Your ref: SSD-10399-Mod-4
File no: MC-20-00009

SSD-10399-Mod-4 – Prospect Logistics Estate - Modifications to Warehouse 1, Clunies Ross Street, Pemulwuy

Blacktown Council's submission to SSD-10399-Mod-4- Modifications to Warehouse 1

Figure 3: Proposed Warehouse 1 Site Plan (Source: Watson Young)

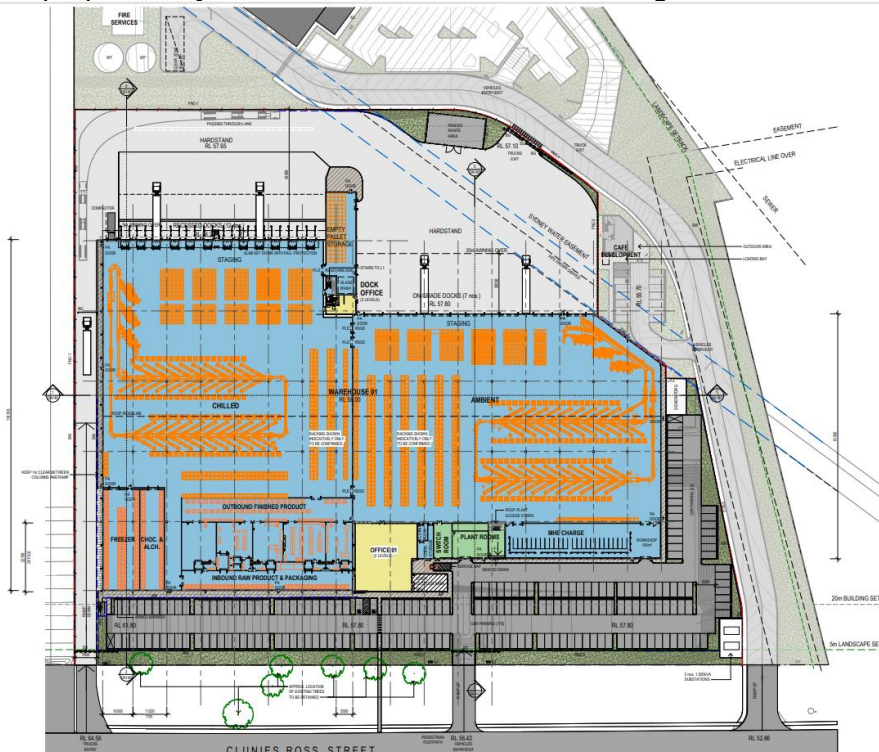
- a. Tree planting is required to be provided with at maximum intervals of 25 m (9 parking bays) to provide shade for parked cars. This has not been provided in the revised parking areas on the northern side of Warehouse 1.

- c. There is a lack of pedestrian connectivity from the café car park to the northern car park of Warehouse 1. The pedestrian access paths should be connected to provide safe pedestrian access between these areas.

- d. The fenced waste area located along the western frontage of the site of Warehouse 1 does not appear to have been previously approved in this location. It should be noted this is not considered to be the most appropriate location given it is located on a road frontage. Please provide clarification on this area, and include within the Modification Report what type of waste would be collected and how it will be screened from view.

Figure 4: Proposed Northern Elevation (Source: Watson Young)

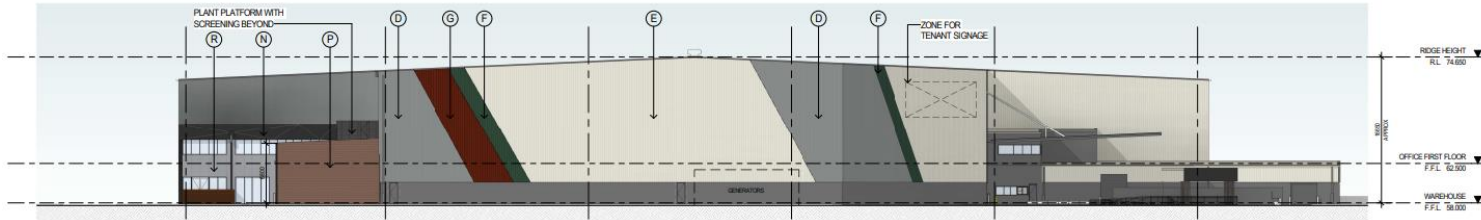
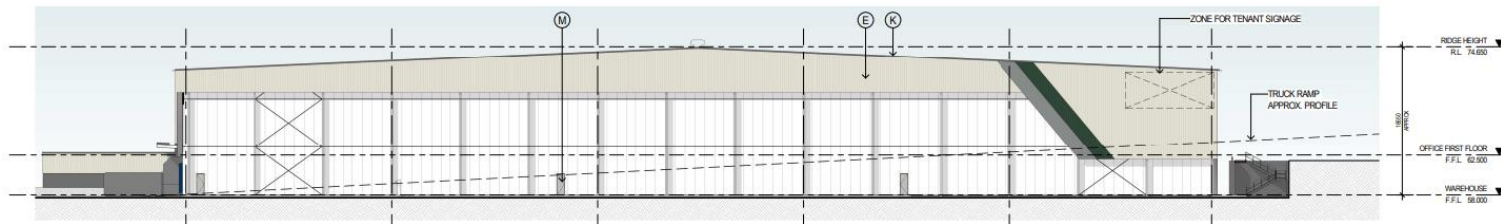
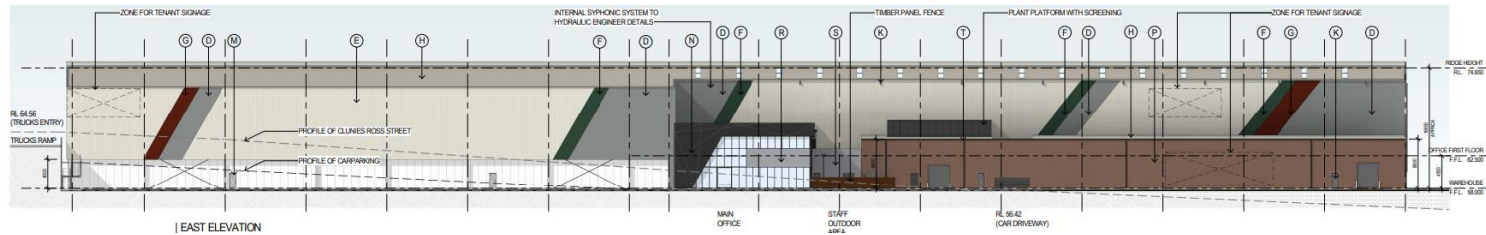
- b. The size of the signage of 40sqm per sign mentioned within the Modification Report is considered to be excessive and should be reduced. The dimensions of all proposed signage should also be shown on the elevation plans.
